Ref: SSD-84090218
Enquiries: Craig Wilkinson

**State Significant Development – SSD-84090218 – MidCoast Regional Organics Facility
– Council Comments on Application**

Figure 3-2: Location of Sensitive Receivers

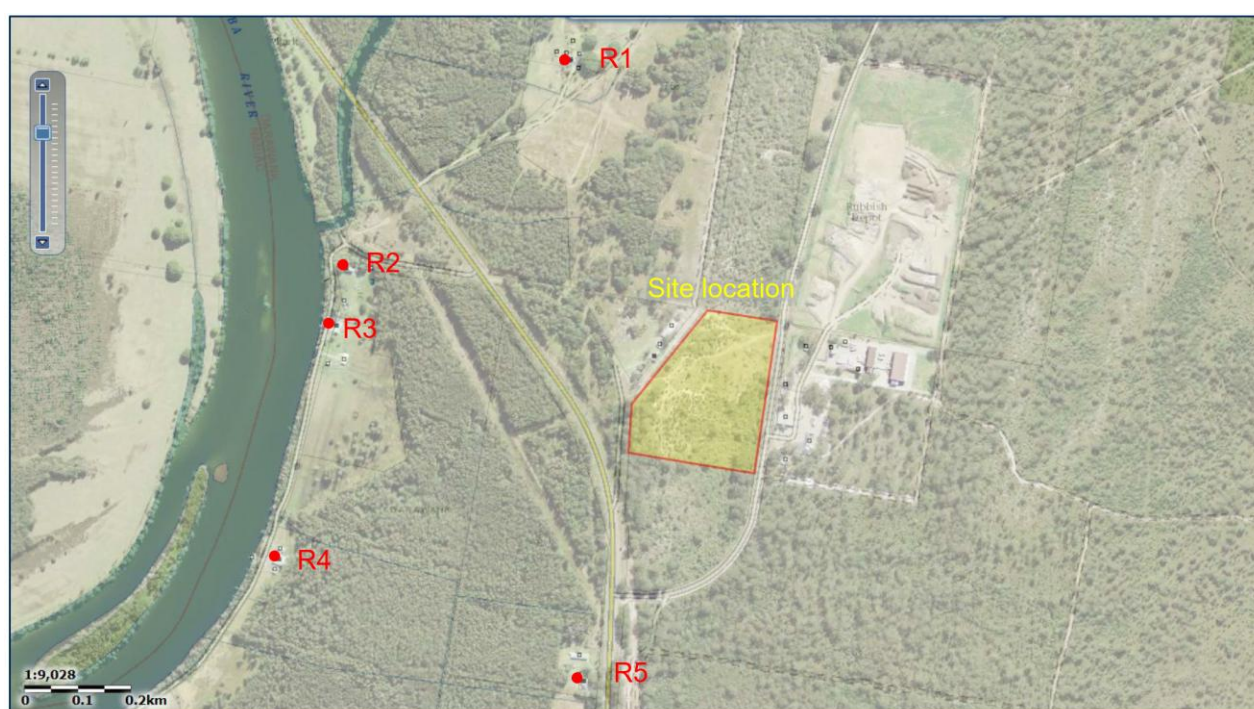
The report identifies the dwelling at 661 The Lakes Way as a sensitive receiver. However, it is noted that a three-lot subdivision has been approved on this property, with the potential for a dwelling to be constructed to the north of the existing residence, closer to Midge Orchid Road, Darawank. The report has not considered this potential receiver, which may be subject to greater noise impacts from truck movements associated with the development, particularly vehicles entering and exiting Midge

Orchid Road, Darawank. It is recommended that the acoustic report be amended to include assessment of this receiver.

The report identifies the dwelling at 661 The Lakes Way as a sensitive receiver. However, it is noted that a three-lot subdivision has been approved on this property (DA246/2018), with the potential for a dwelling to be constructed to the north of the existing residence, closer to Midge Orchid Road, Darawank. The report has not considered this potential receiver, which may be subject to greater air quality and odour impacts from this facility. It is recommended that the air quality and odour assessment report be amended to include assessment of this receiver.
